Ribble Valley Borough Council
Council Offices
Church Walk,
Clitheroe
Lancashire
BB7 2RA

Phone: 0300 123 6780
Email: Kathryn.Walsh@lancashire.gov.uk
Your ref: 3/2024/0643
Our ref: 3/2024/0643/HDC/KW
Date: 20 September 2024

Location: 1 The Spinney Grindleton BB7 4QE

Proposal: Proposed reduction in size of garage from two-cars to one and construction of two-storey extension to the rear.

PROPOSED SITE PLAN

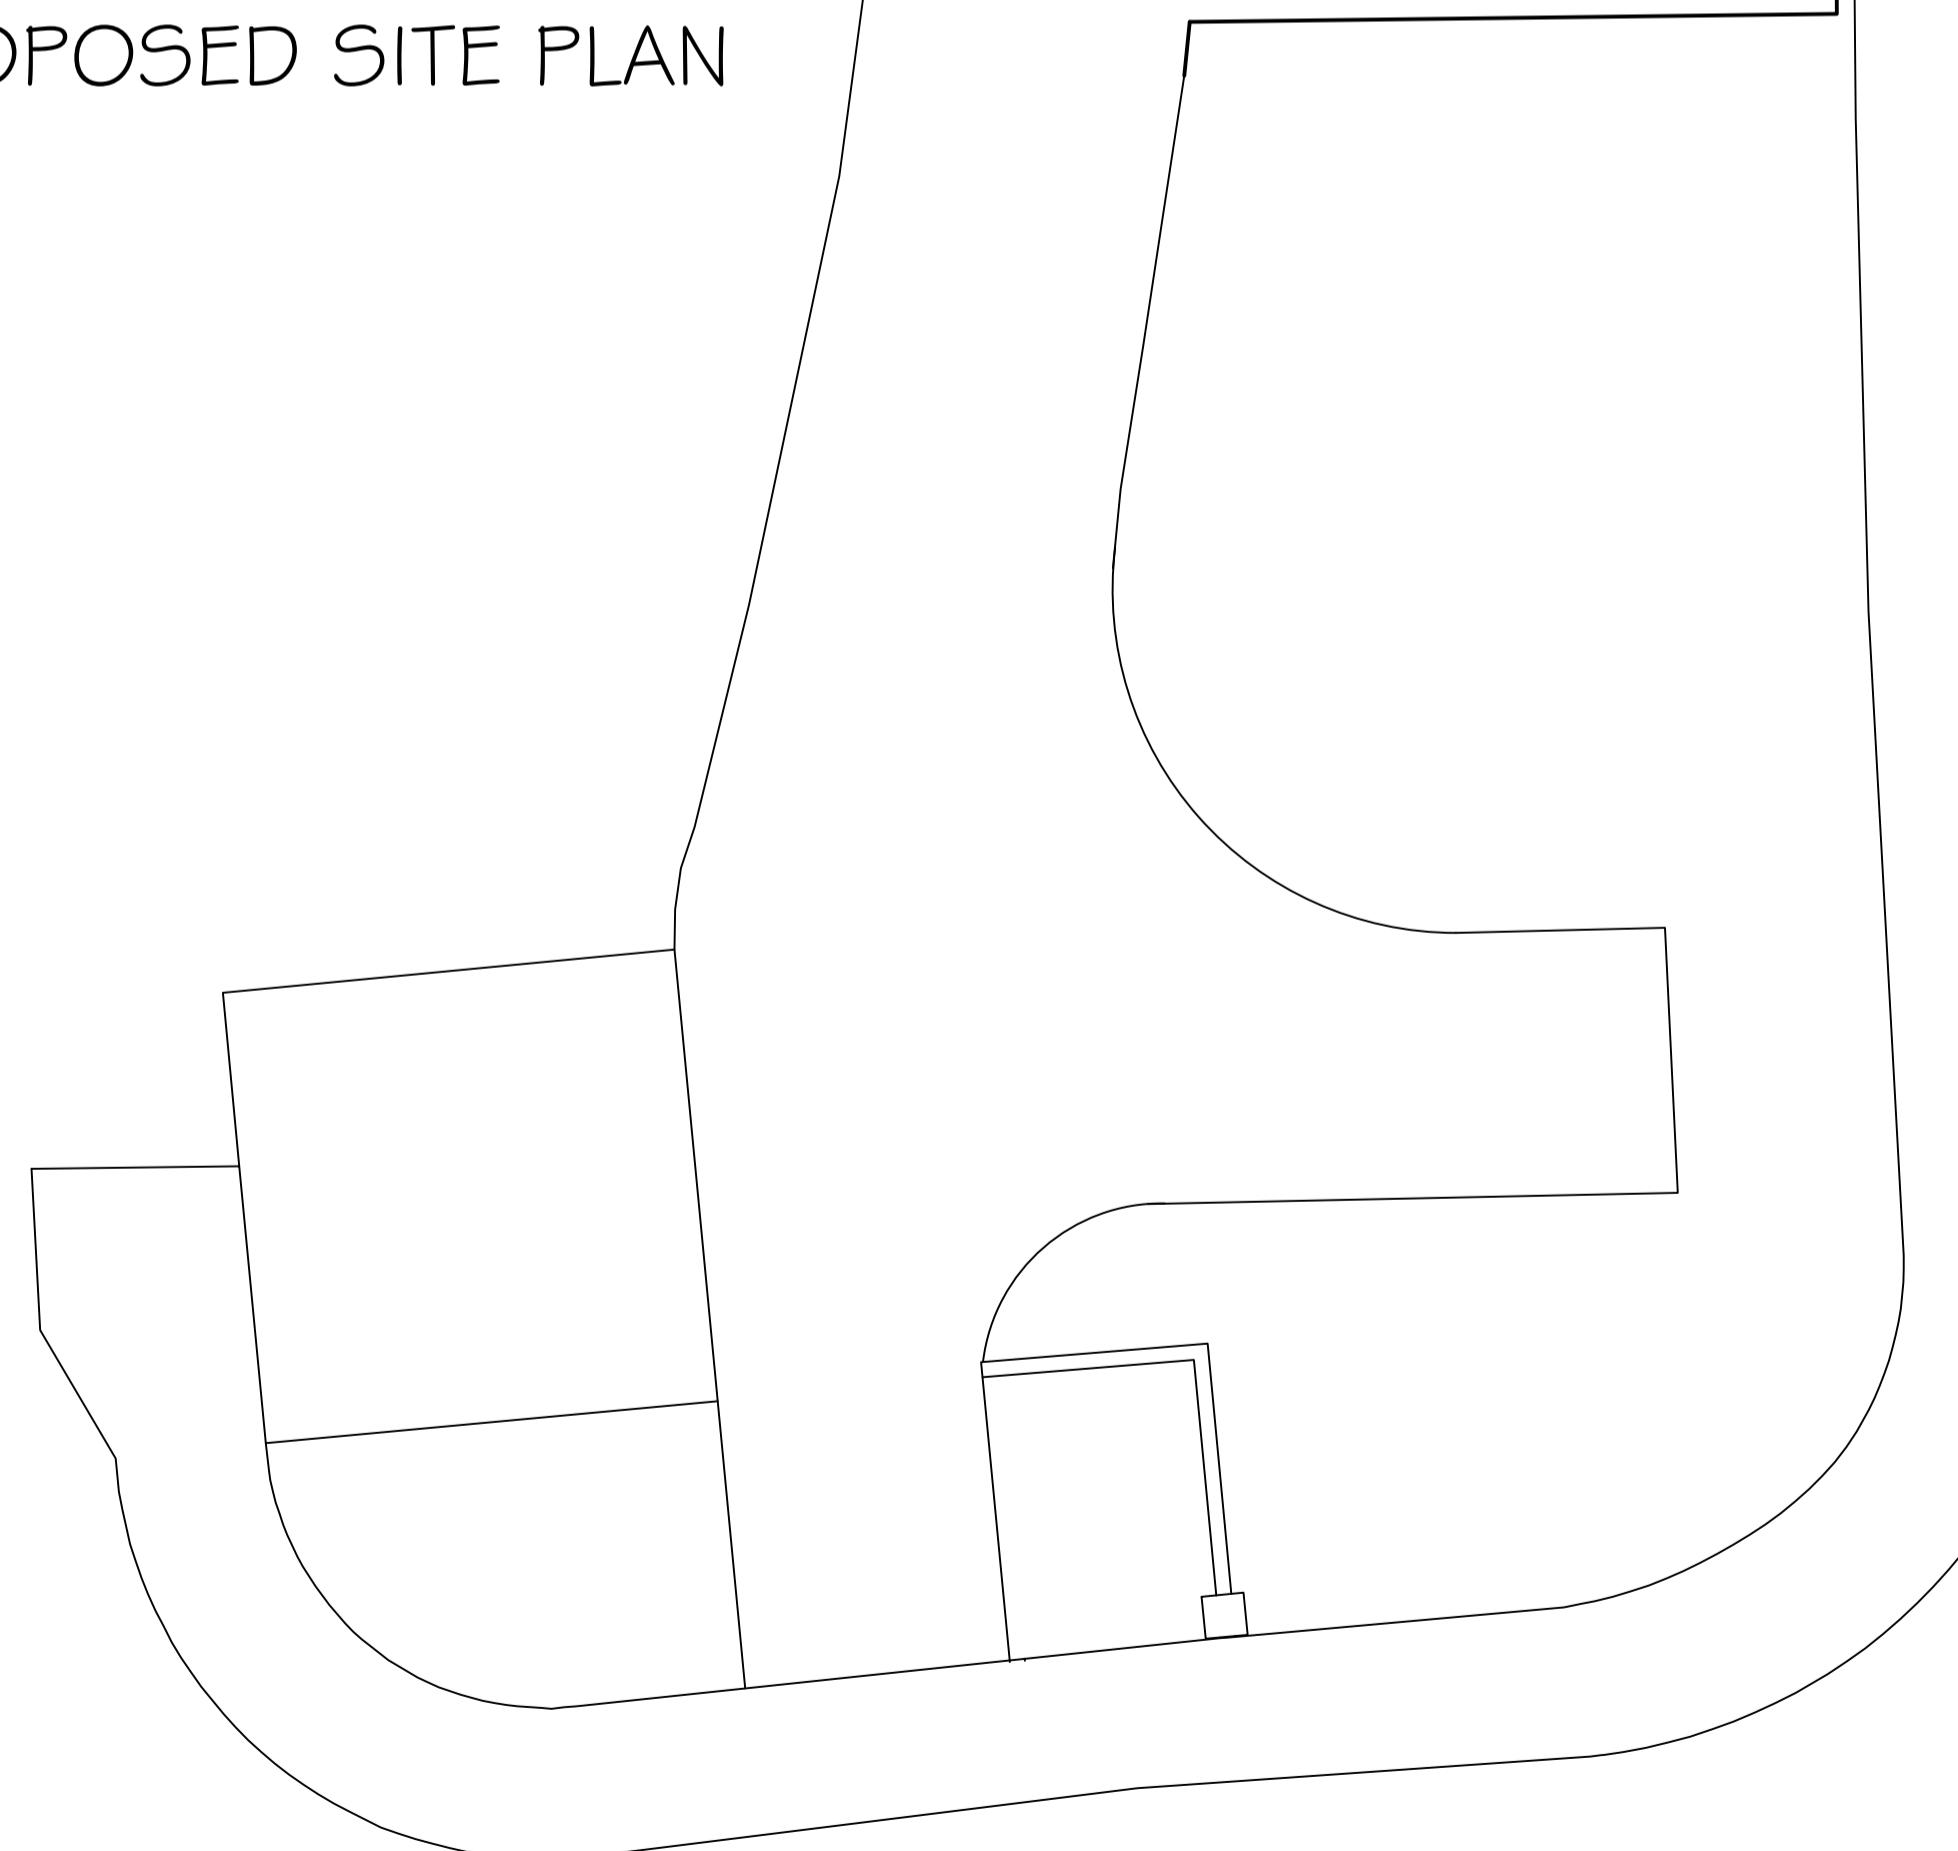
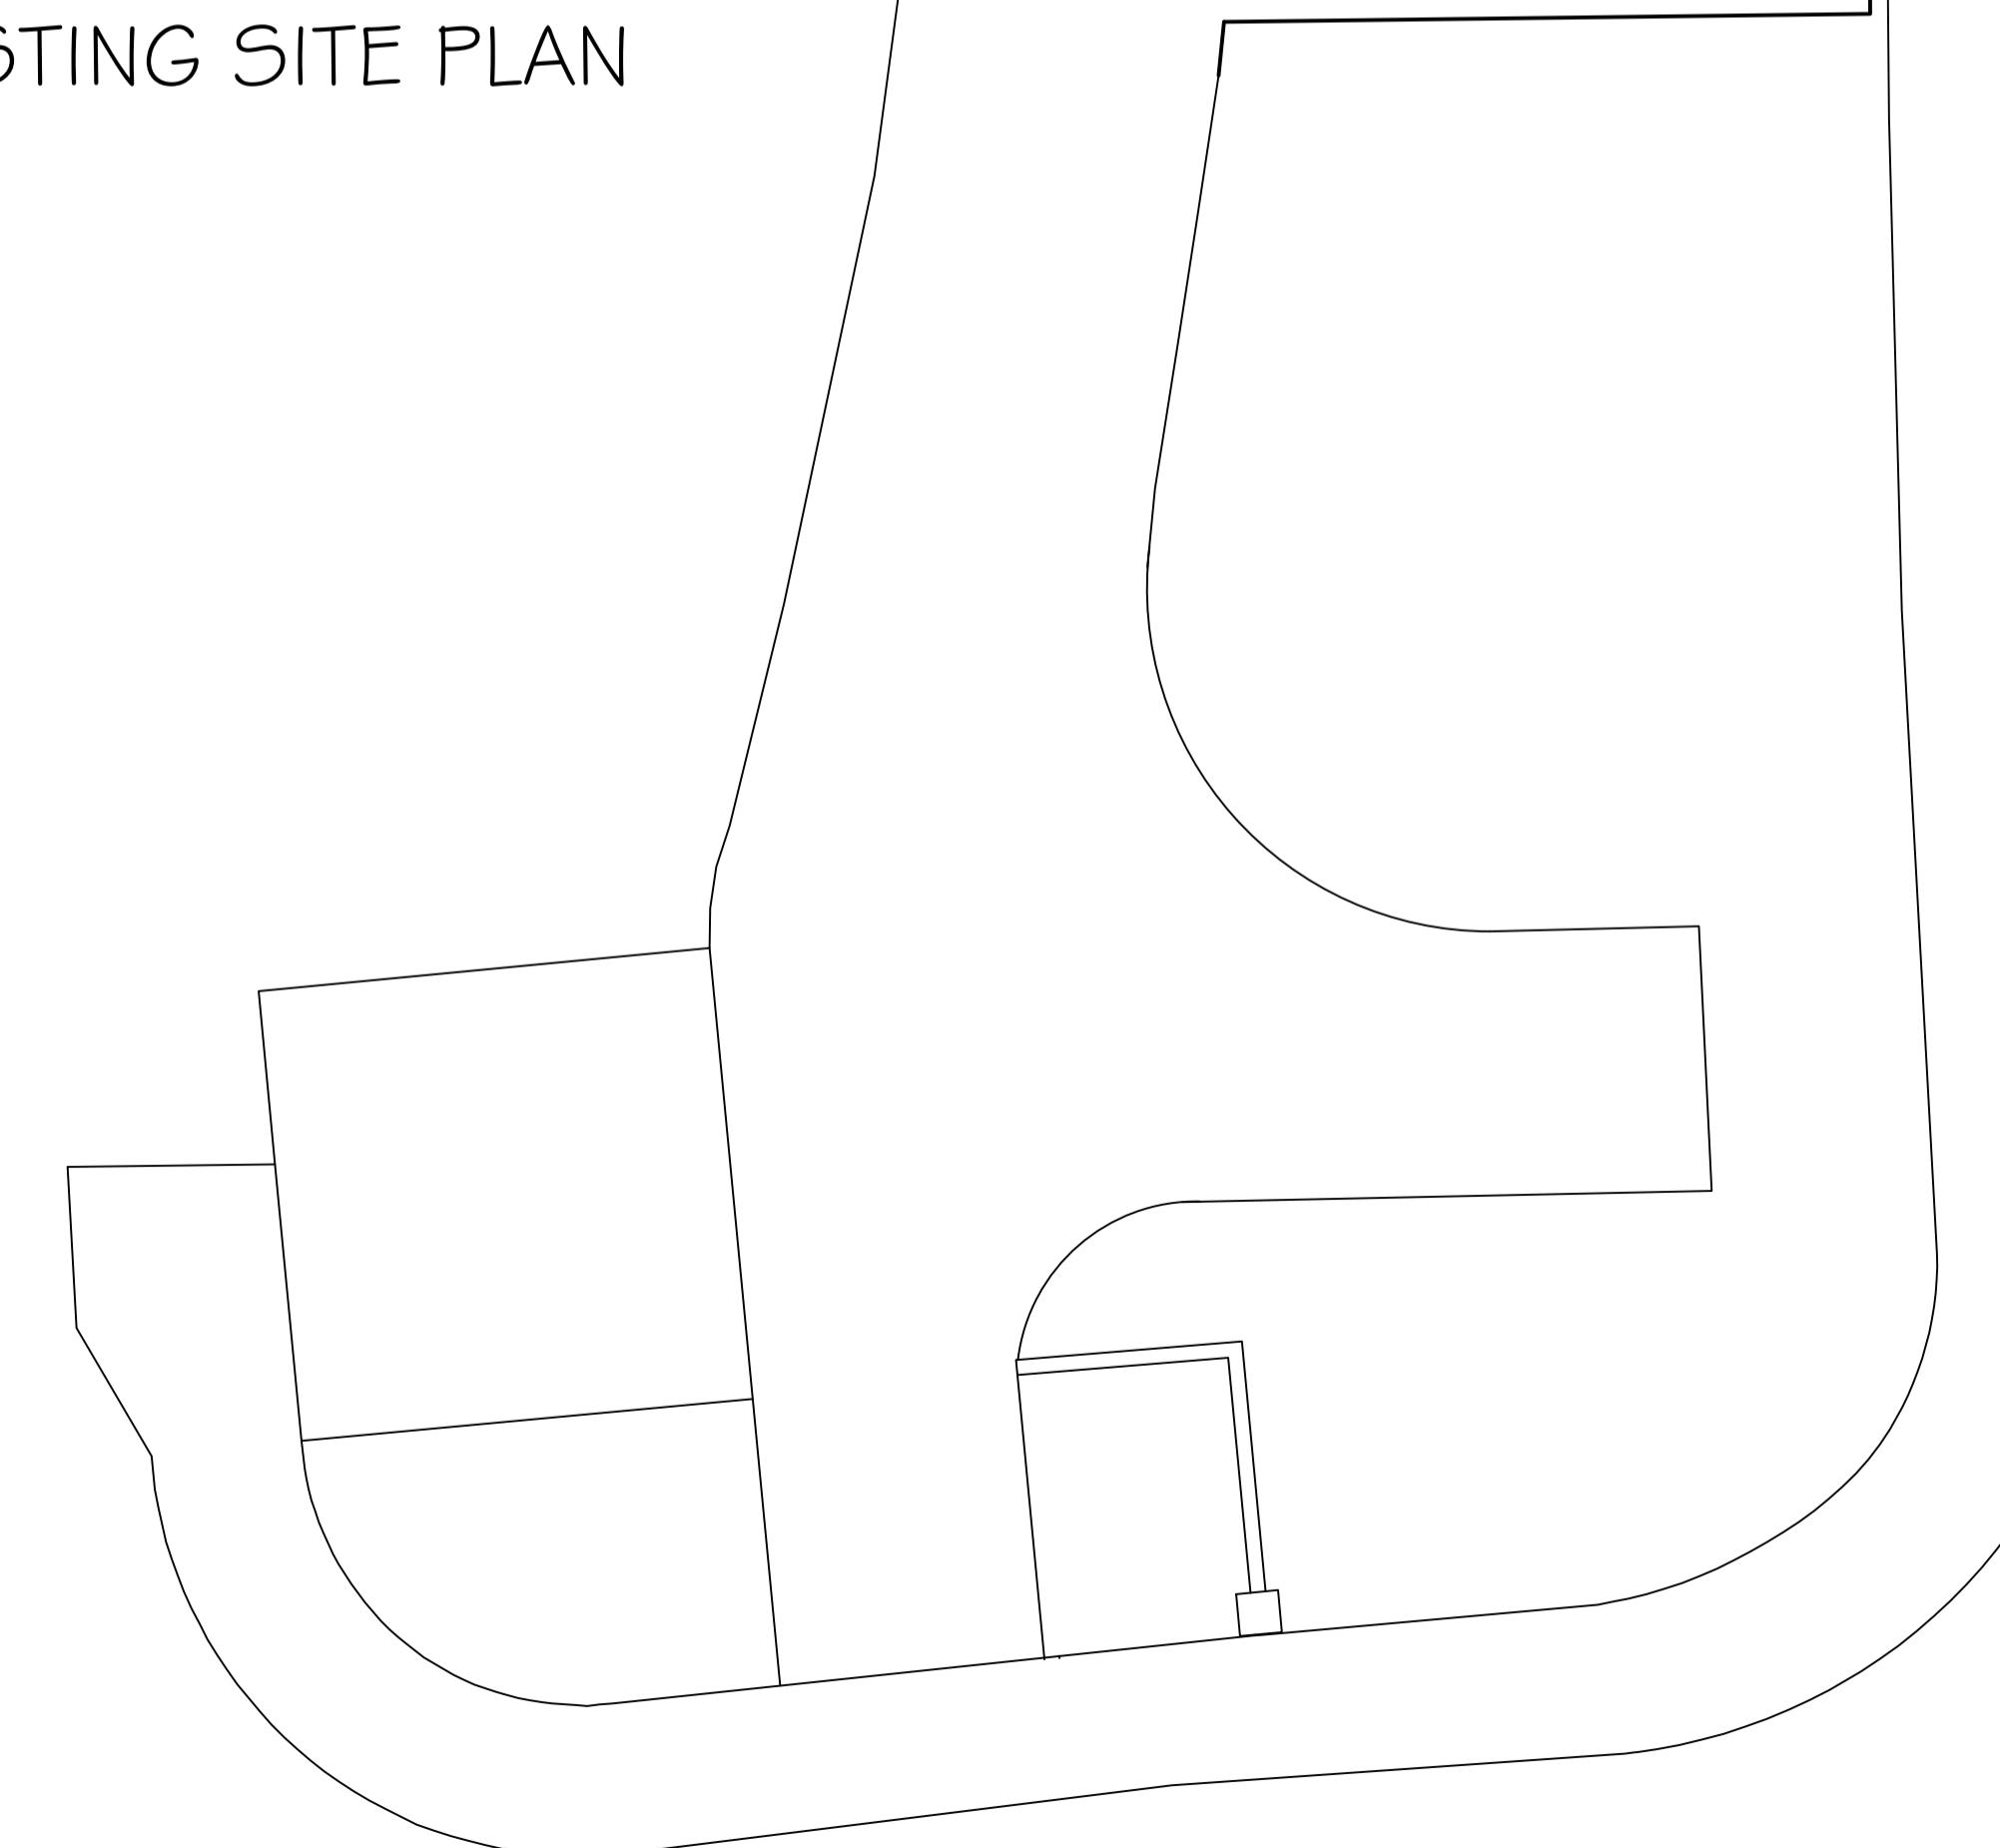
The proposal will increase the number of bedrooms within the dwelling, a 4+ bedroom dwelling should have at least 3 off street parking spaces to comply with the LHAs parking standards as defined in the Joint Lancashire Structure Plan.

The proposal also includes the reduction of an existing double garage. The recommended minimum internal dimensions for a single garage size is 6m in length and 3m wide. The recommended distance of 6m is based on the length of a large family car (Ford Mondeo Estate 4.58m long), clearance at the rear of the car (200mm), overhang of the garage door (600mm) and room to stand in front of the car and open/close the garage door (600mm). Where garages are smaller than the recommended minimum internal dimension of 6 x 3m they should not be counted as a parking space.

Whilst the amended garage does not meet the recommended internal dimensions there is ample space within the existing driveway to support 3 off street parking spaces and turning within the site as such, the effect of the development on the operation of the local highway network would be negligible.
